Case Officer: Rebekah Morgan

Recommendation: Approve

Applicant: Morley Stores

Proposal: Discharge of conditions 4 (means of access), 5 (turning area details), 6 (detailed scheme for the surface water and foul sewage drainage) and 9 (Construction Environment Management Plan) of 20/02139/F

FTA Design Articulated Vehicle (2016)

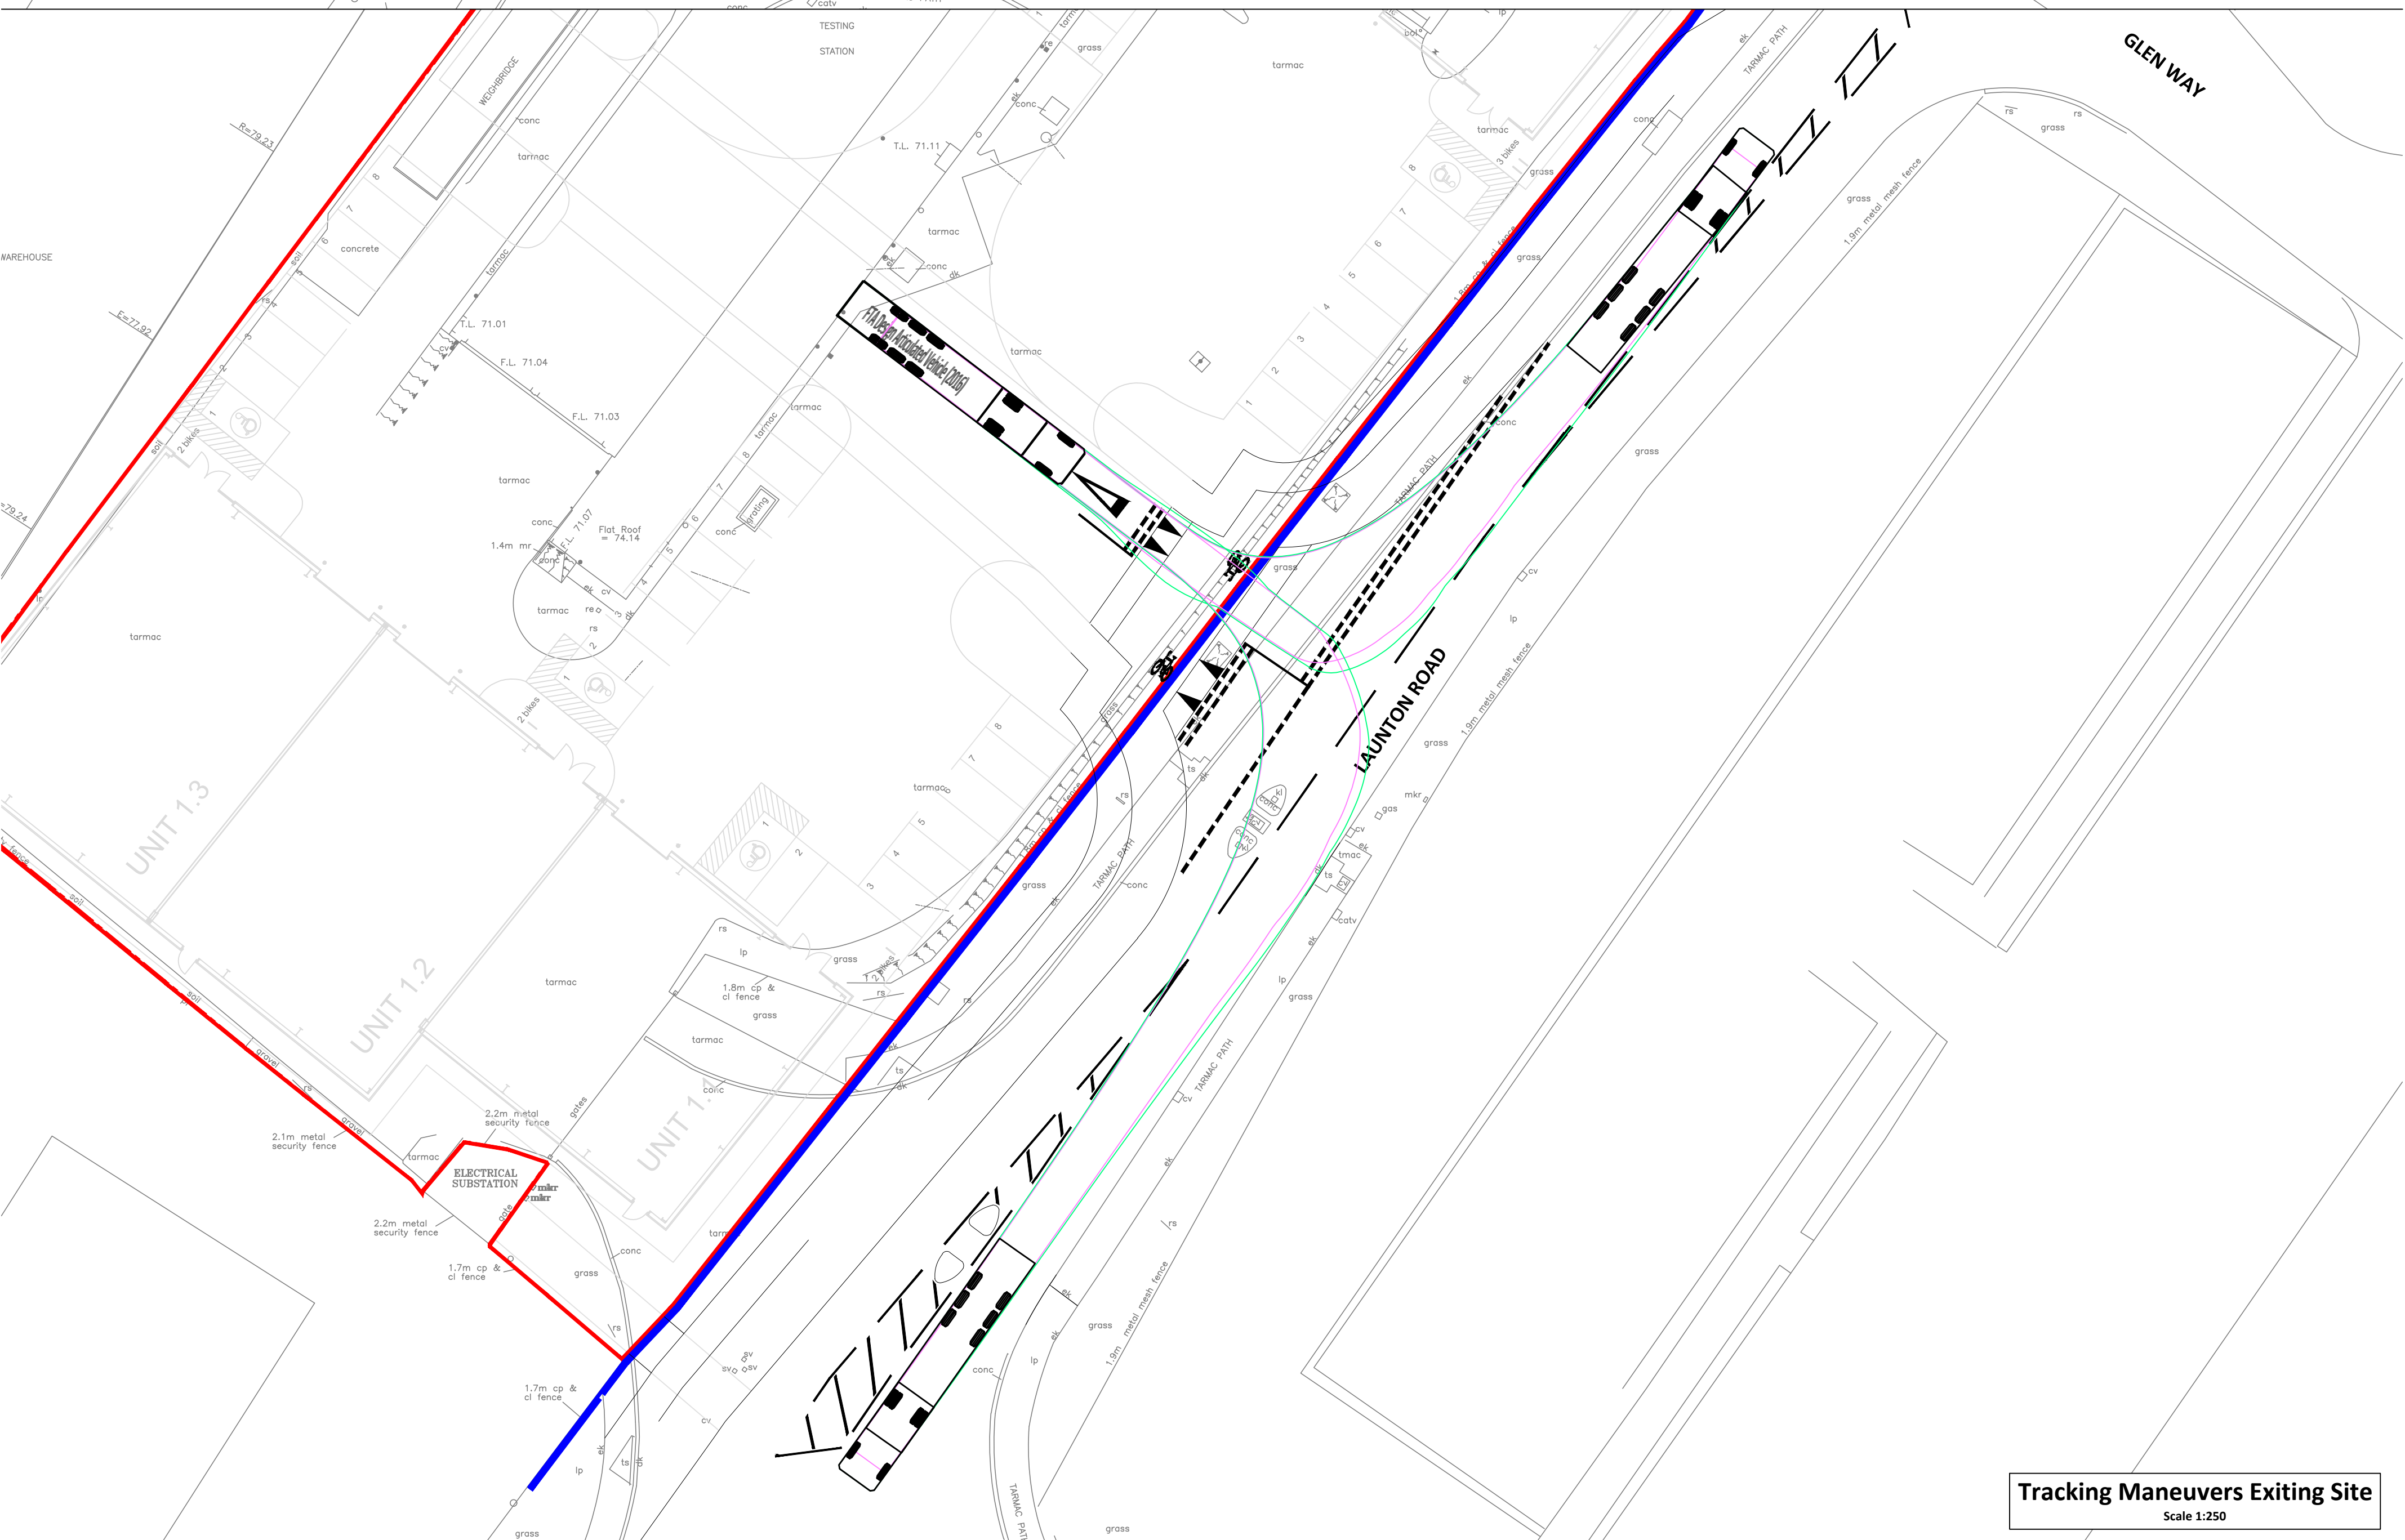
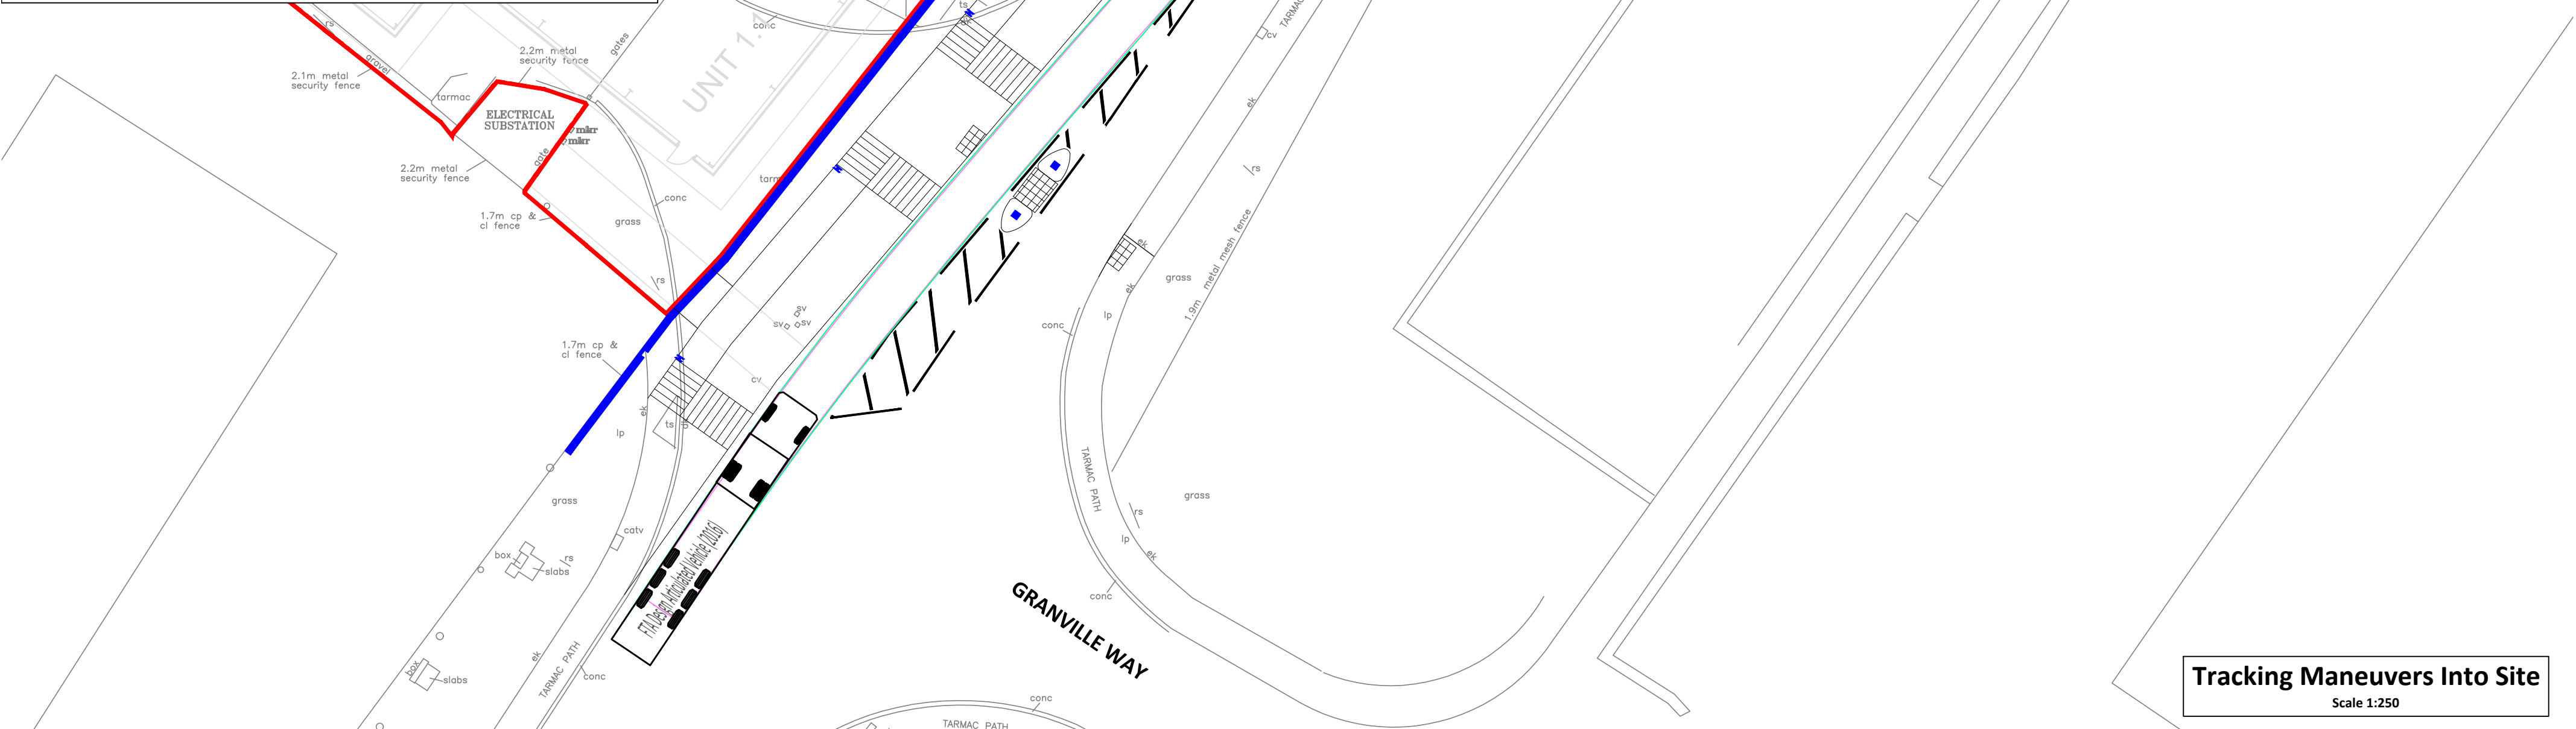
Condition 5 – The submitted tracking diagrams show an articulated vehicle safely entering and exiting the site.

- 5.2. Condition 5 – The applicant has demonstrated a layout that provides 49 parking spaces and sufficient space for the manoeuvring of an articulated vehicle to enter/exit the site. OCC Highway officers confirmed the details are acceptable.
